Applicant's Response to S51 Advice

14 October 2024

Project Title: North Falls Offshore Wind Farm

Application Reference: EN010119

NORTH FALLS
Offshore Wind Farm

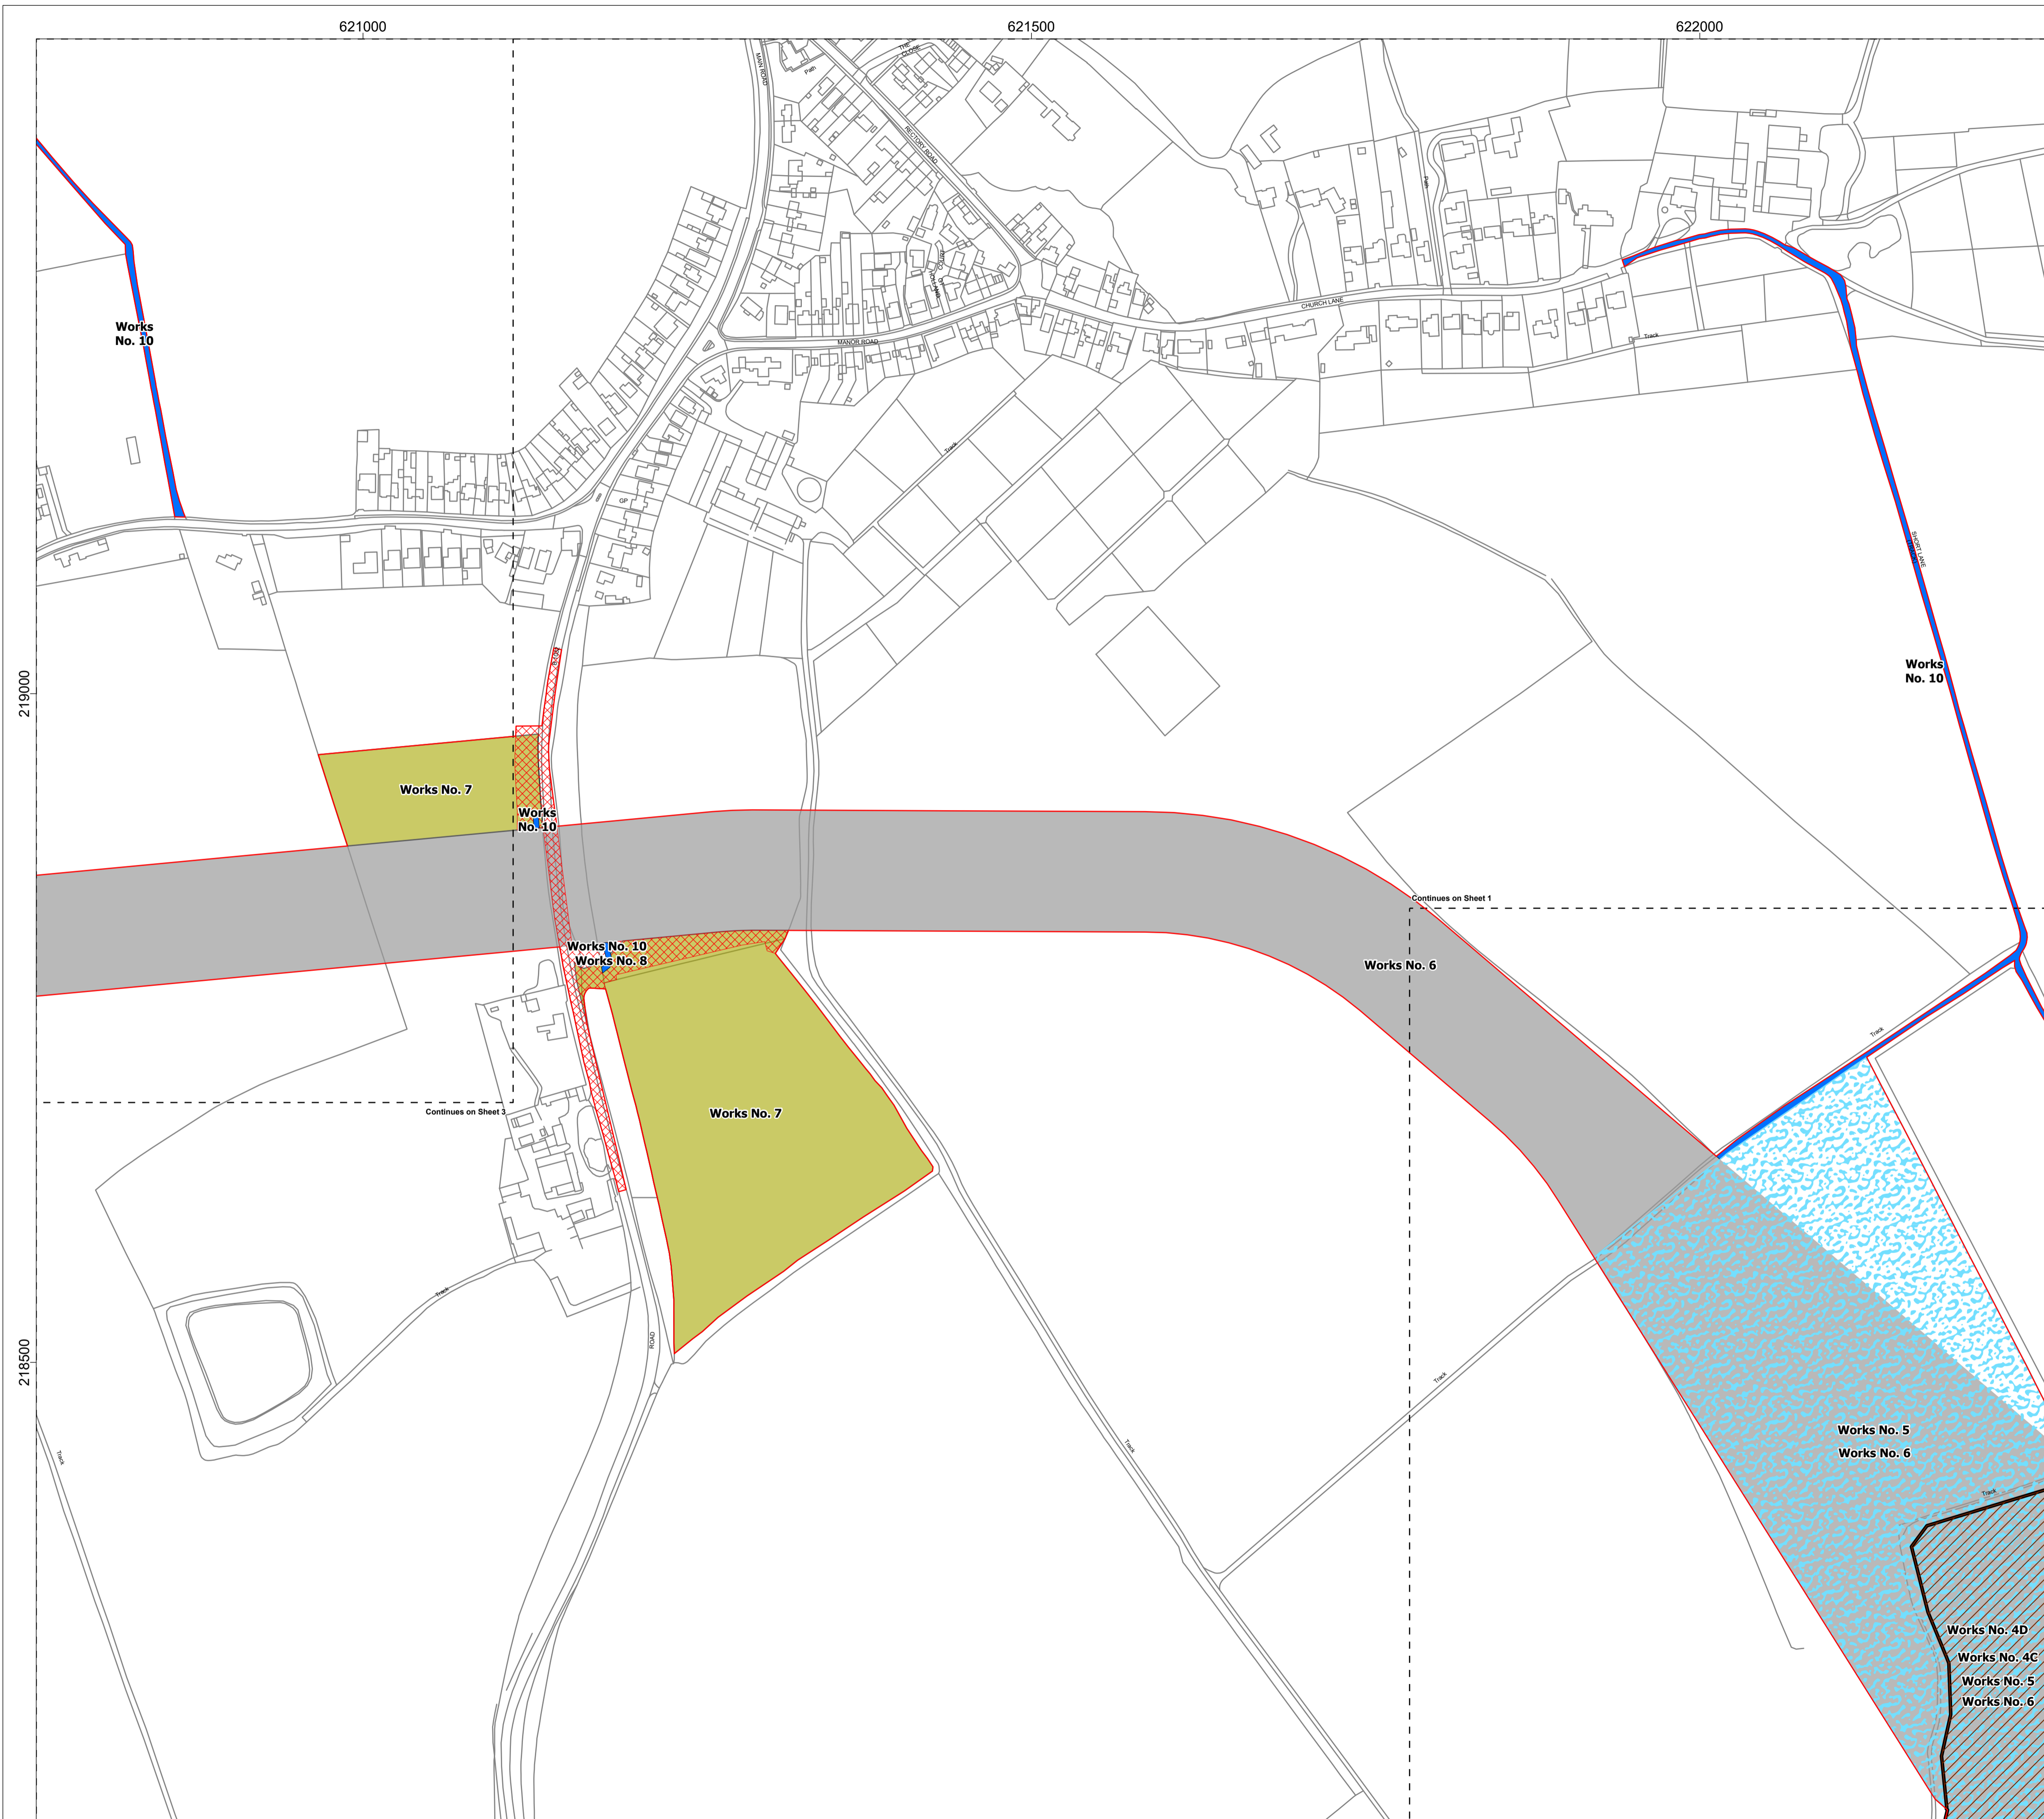
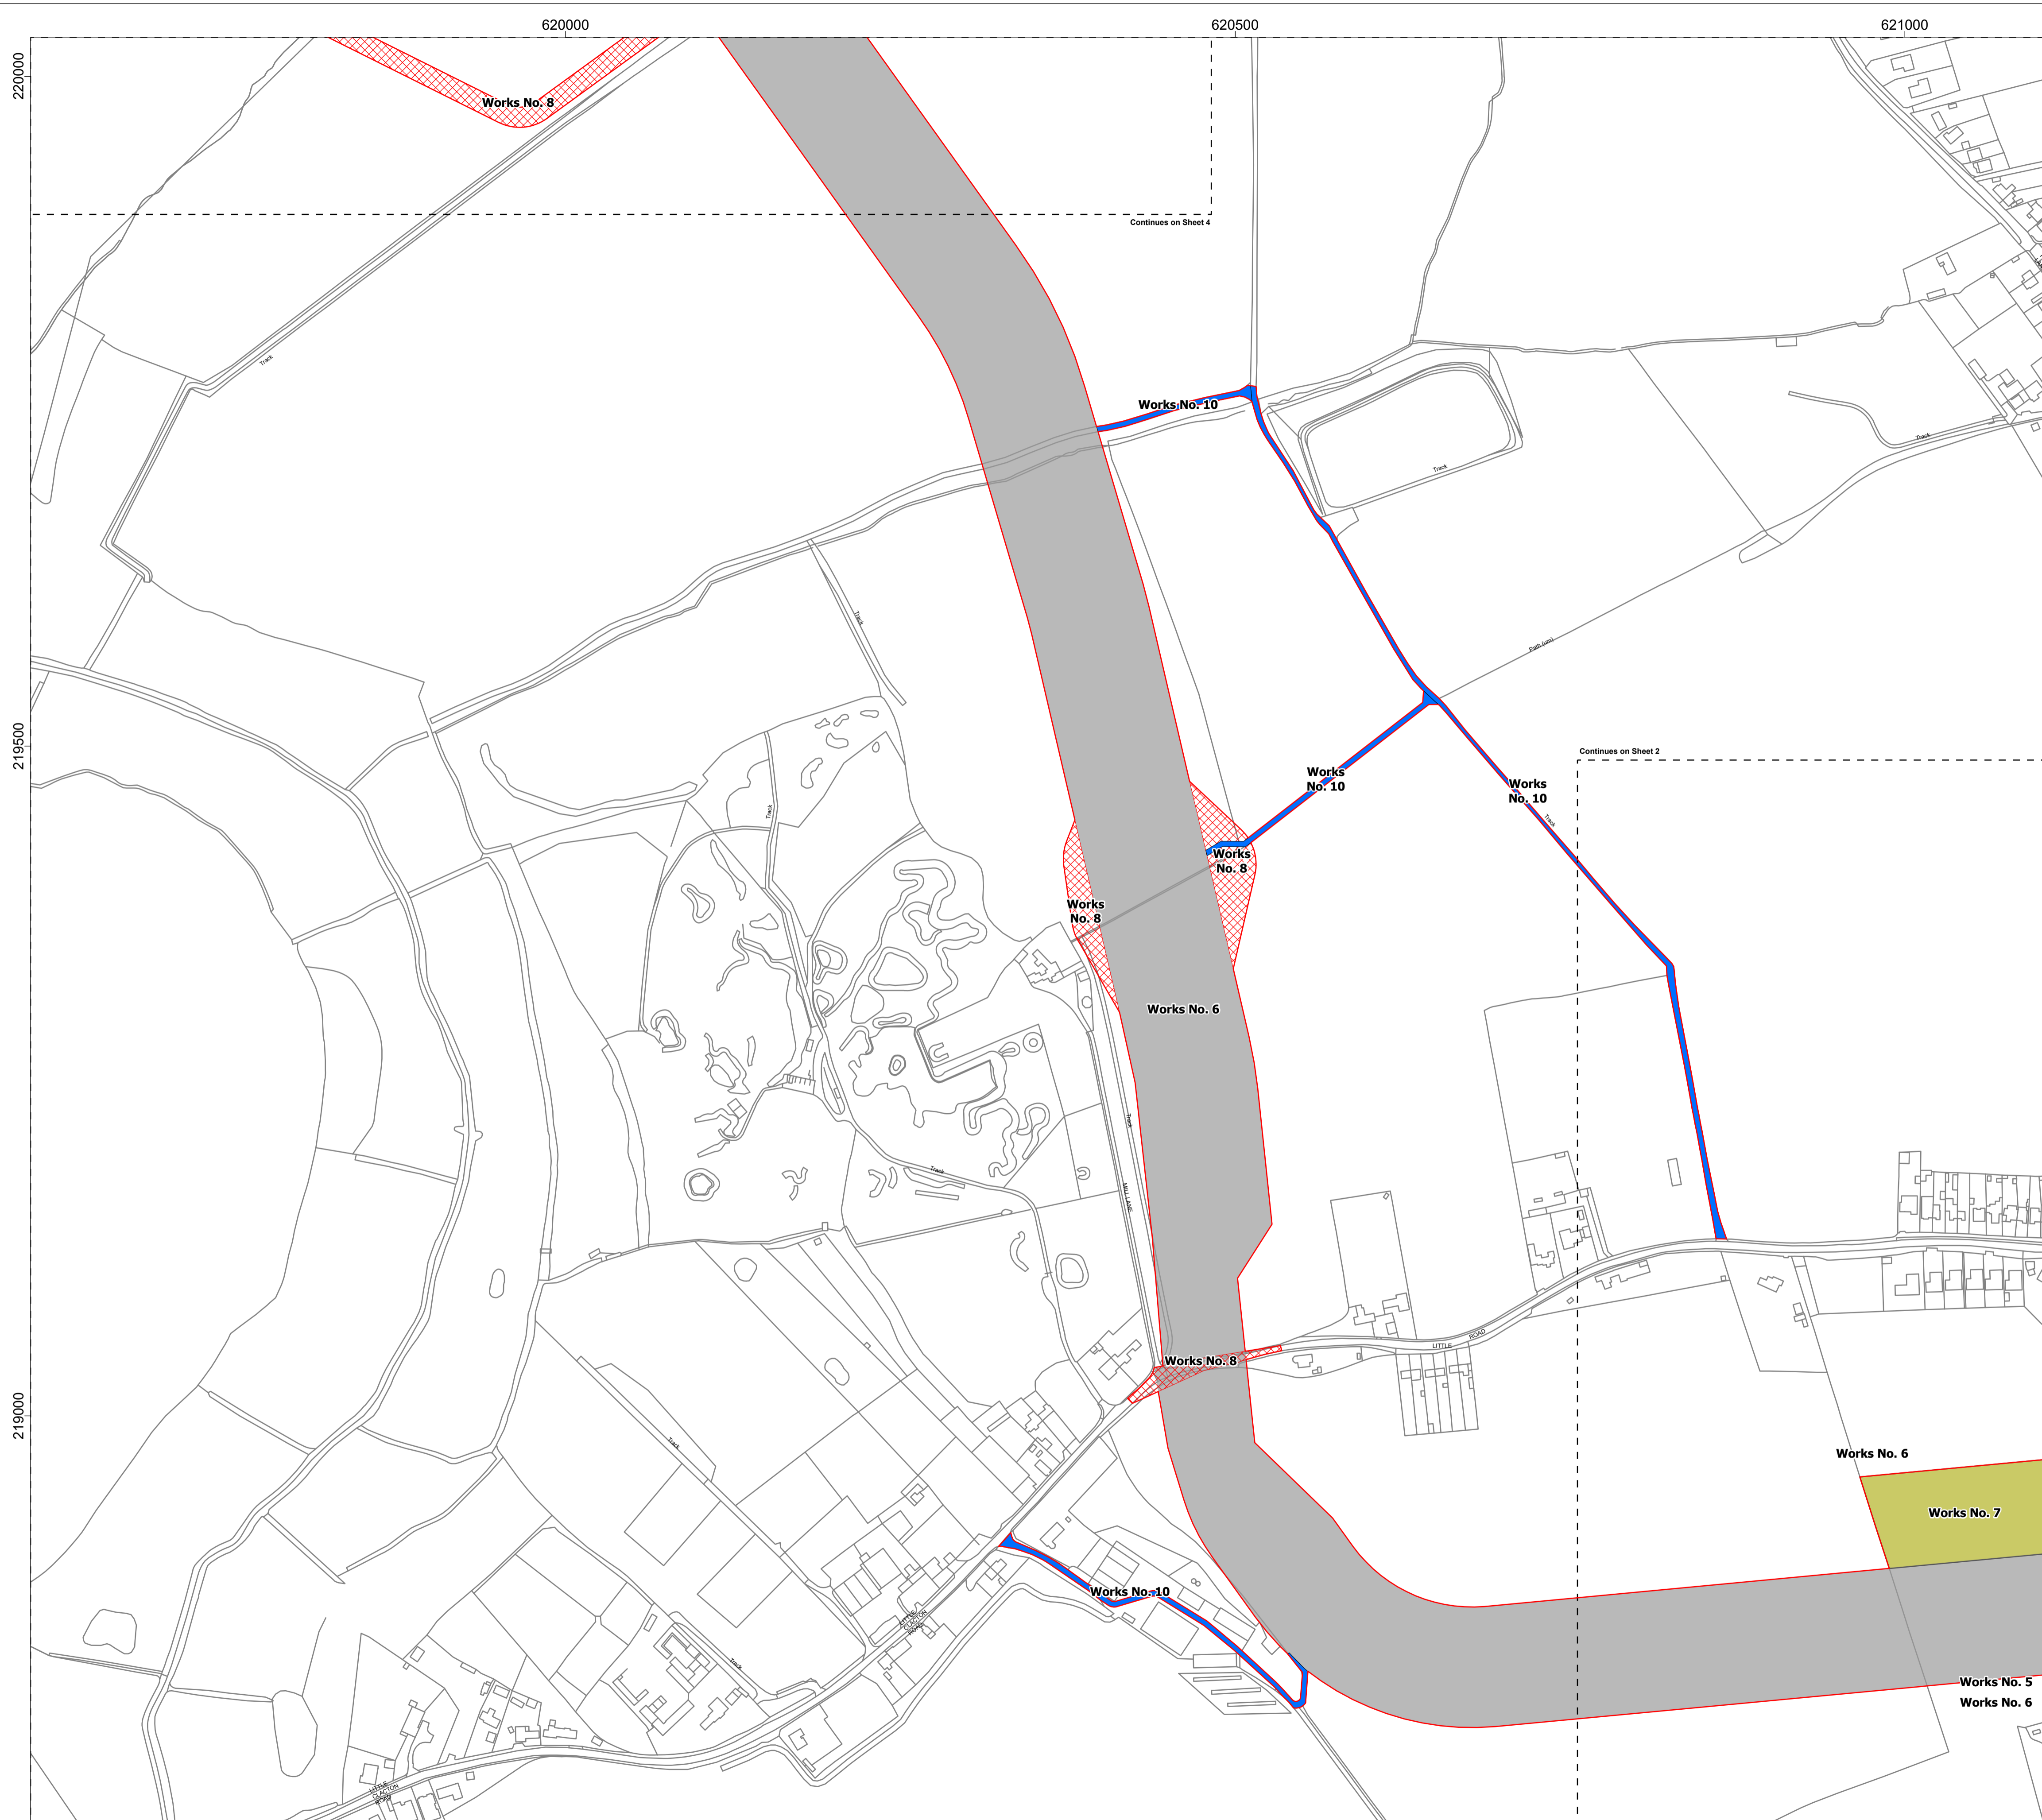
Works Plan Onshore (Doc 5.6)	
Comment or Query	Applicant's Response
<p>Summary descriptors are not provided for each work area.</p> <p>The Works Plans do not contain any identifying information, such as village or road names, which are shown on the Location Plans.</p> <p>Adding summary descriptors, local place and road names to the Works Plans would aid understanding for stakeholders.</p> <p>Similarly, the location of the 'red line' boundary must be clear in all areas. Once identifying information labels are added to the plans, please ensure that these can be digitally searched.</p>	<p>The Applicant has updated the Works Plans in response to this section 51 advice, which are submitted alongside this response.</p>
